Planning Application 3/2020/1061
Pendle View, Primrose Lane, Mellor BB2 7EQ
Proposed Erection of a Seven Bedroom Holiday Cottage.

[REDACTED] I write to object against the above planning application
[REDACTED] I ask for the following to be taken into consideration:

Title: Proposed Plans and Elevations.

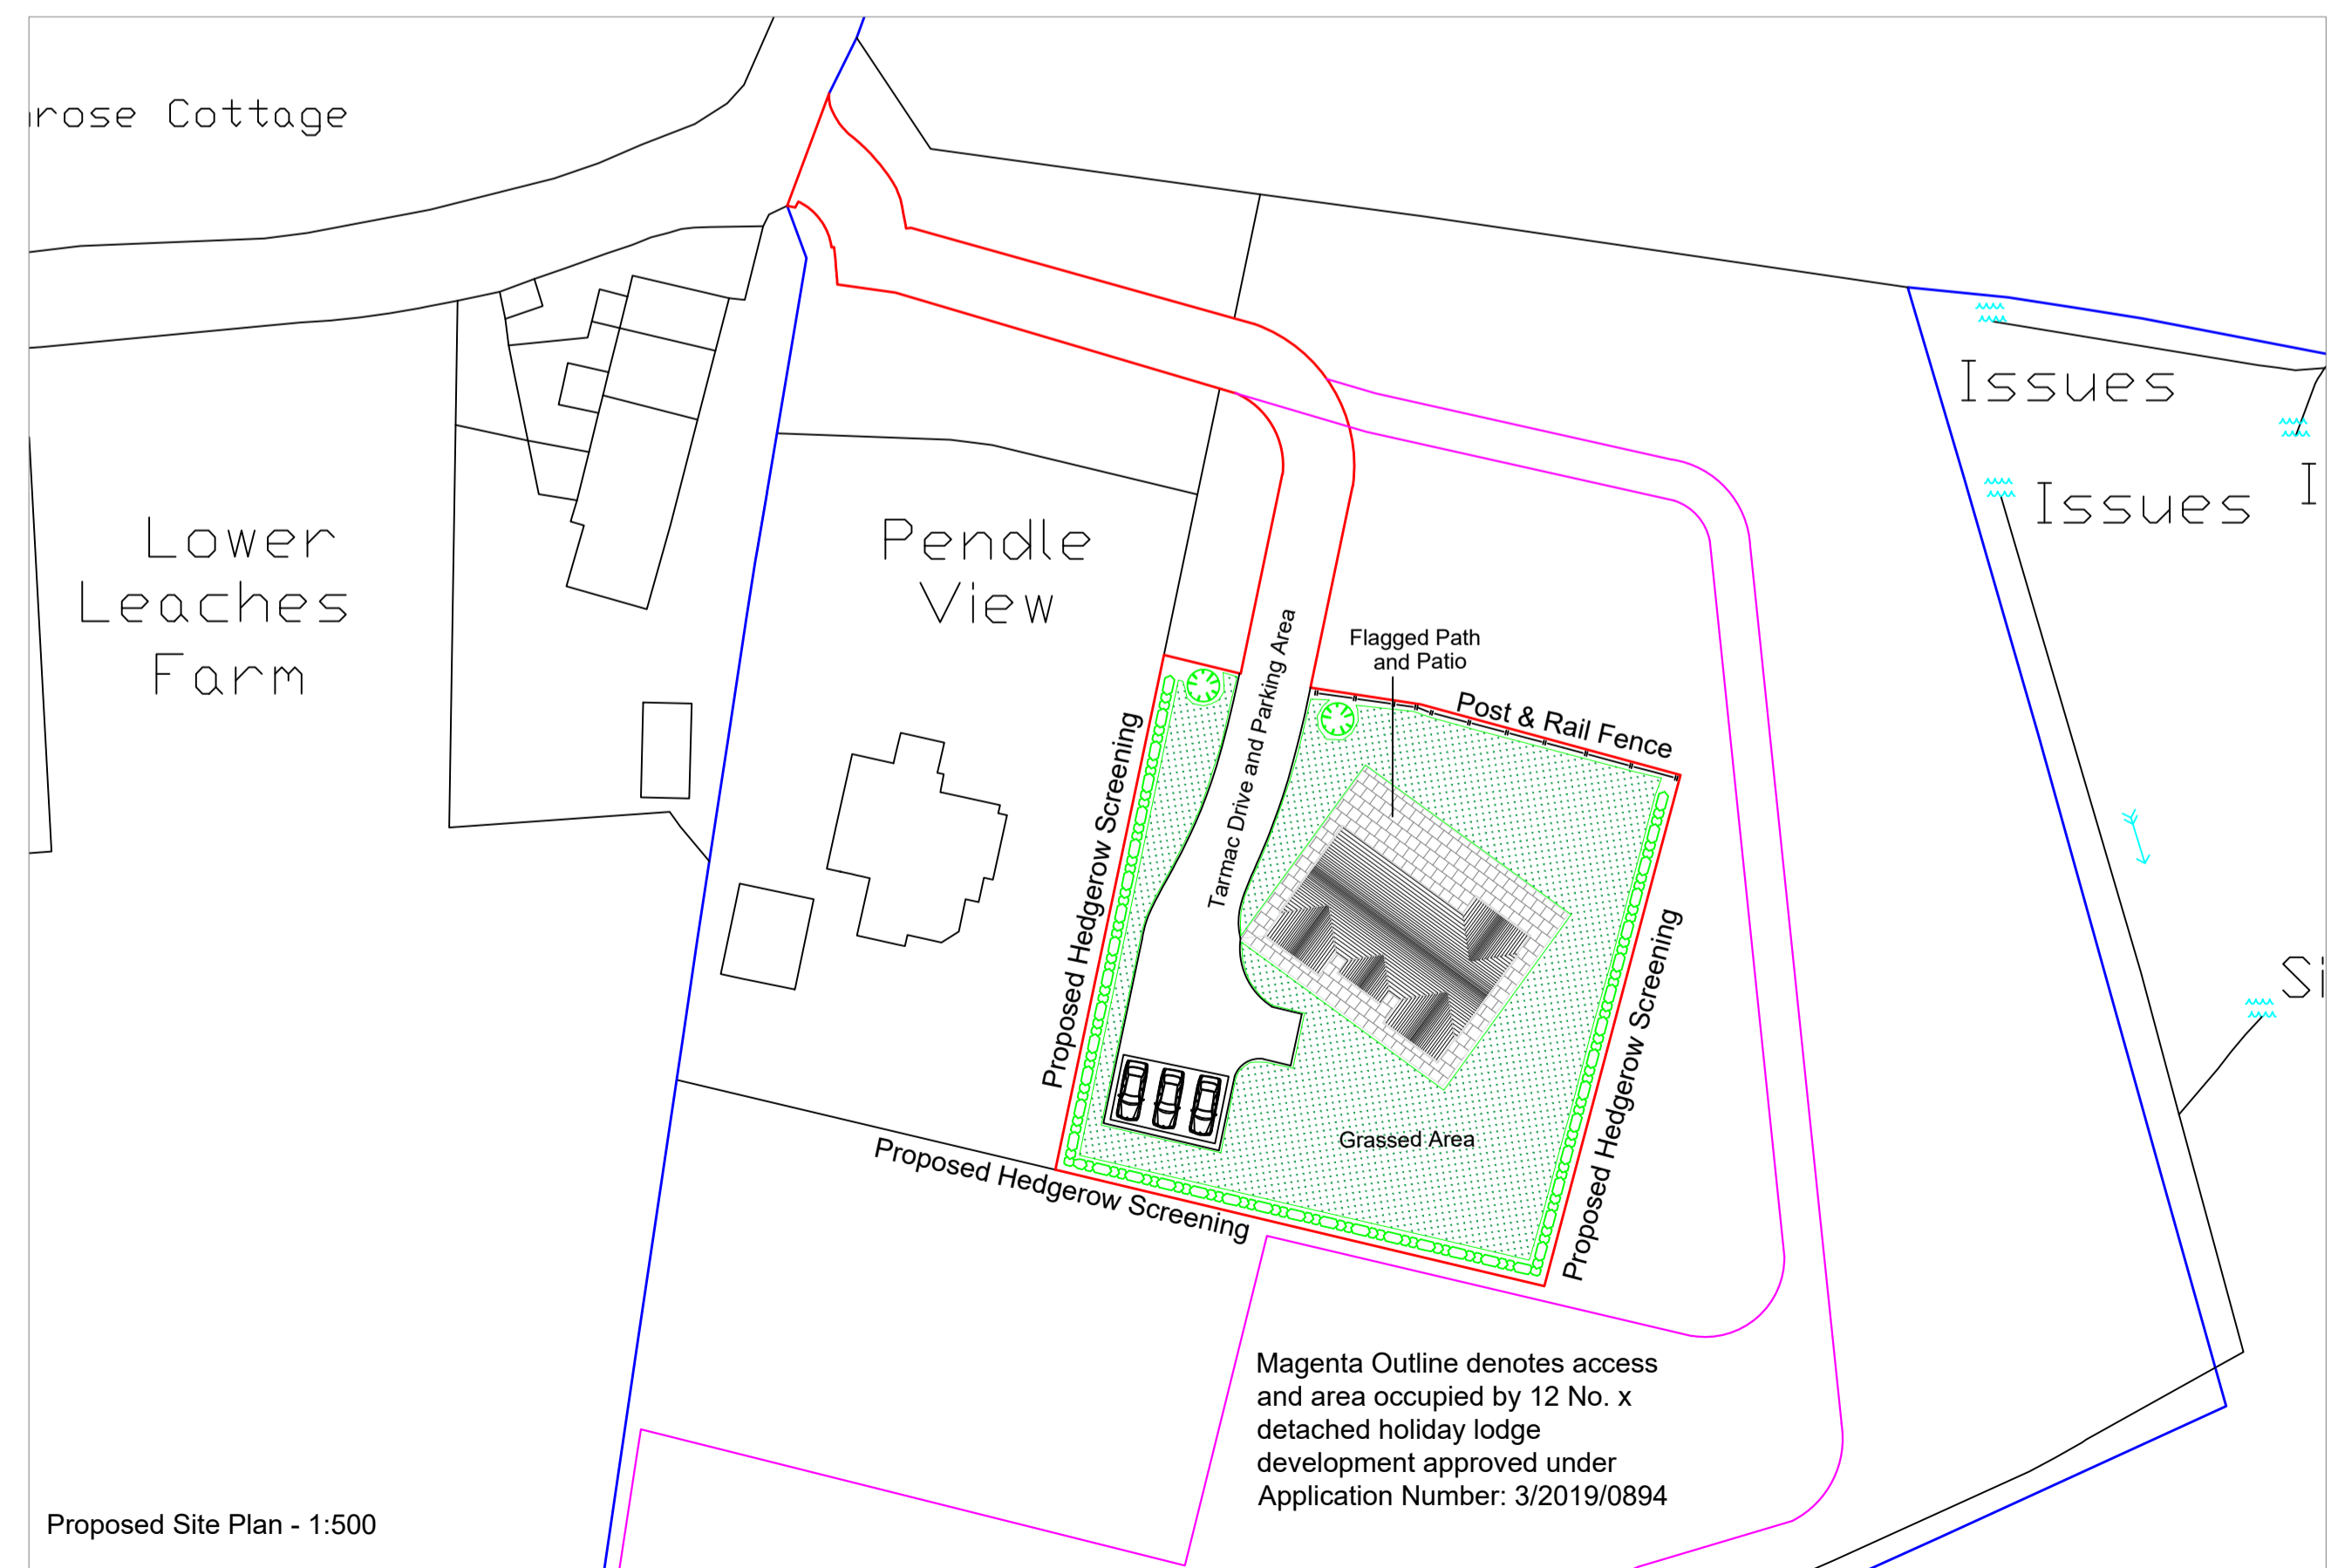
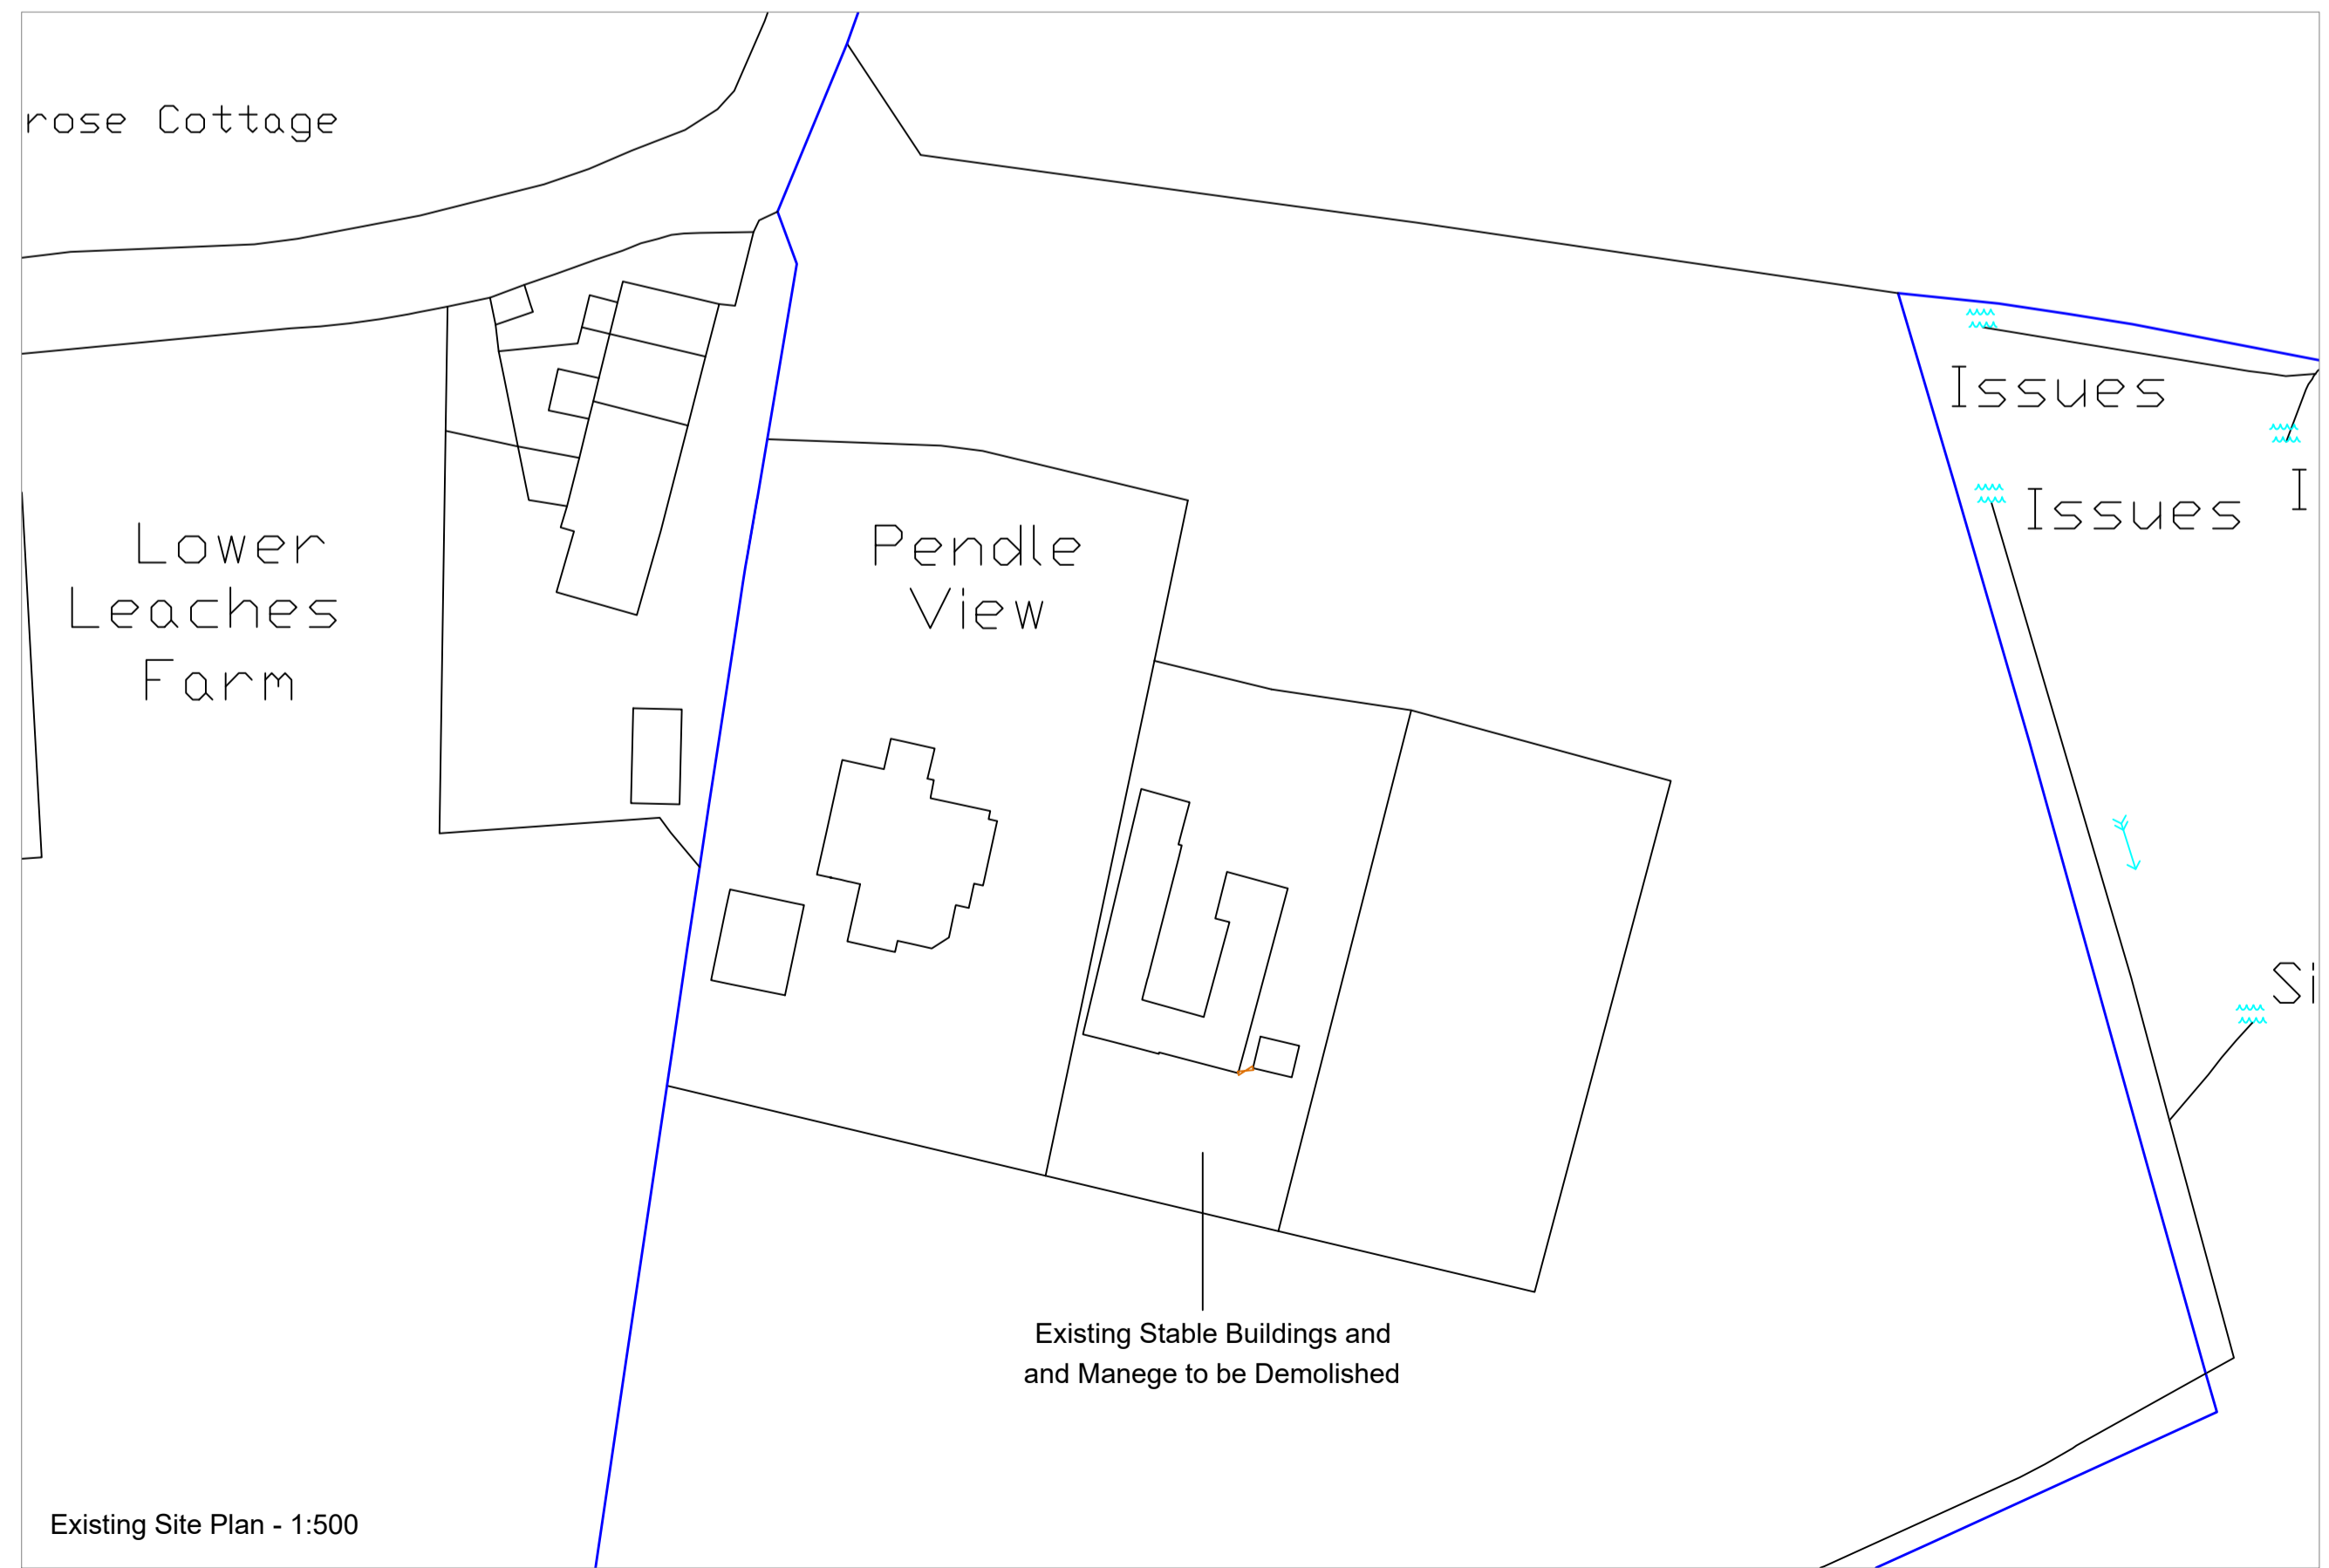
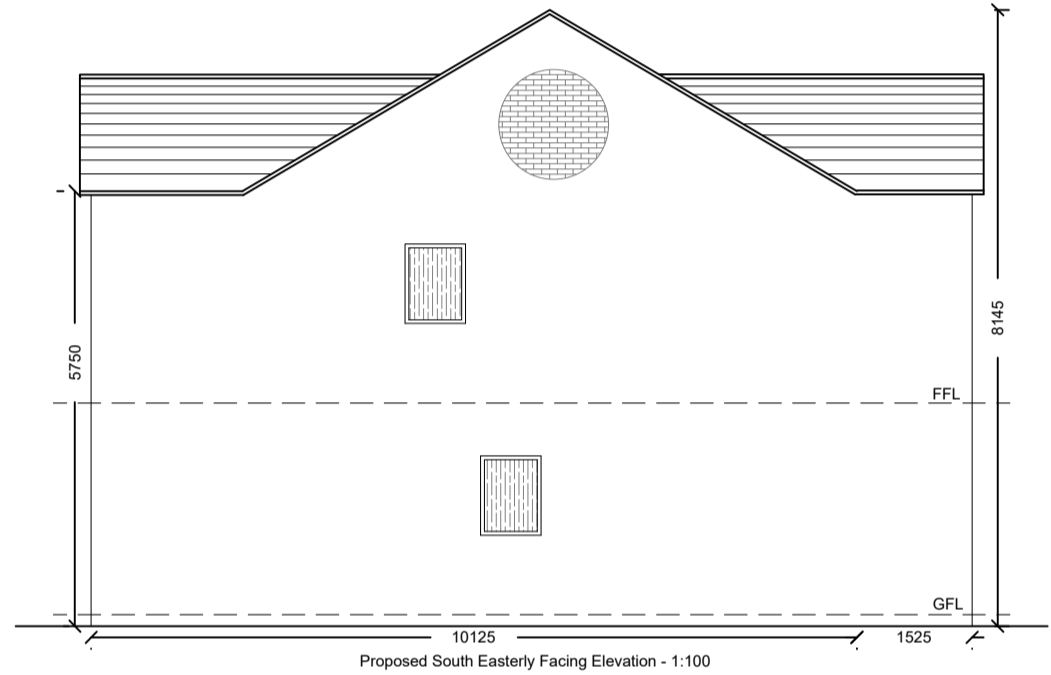
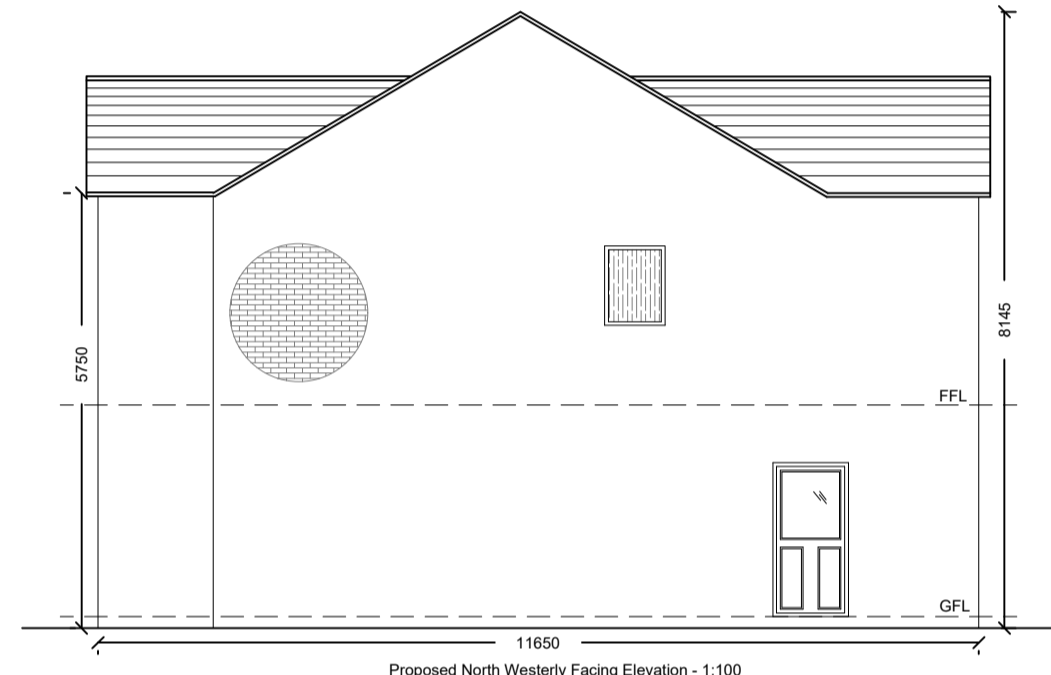
Visual Amenity. The design is not in keeping with the local area and will have a negative effect on the visual amenity. The property is to be constructed of brick, this is out of keeping with the present house on the applicants site Pendle View and the nearby properties of Lower Leaches Farm, Primrose Cottage and Mellor House, which are all constructed from stone. This proposal does not relate in design or use to the current buildings on site and in the neighbourhood and has no related benefits to the local settlements.
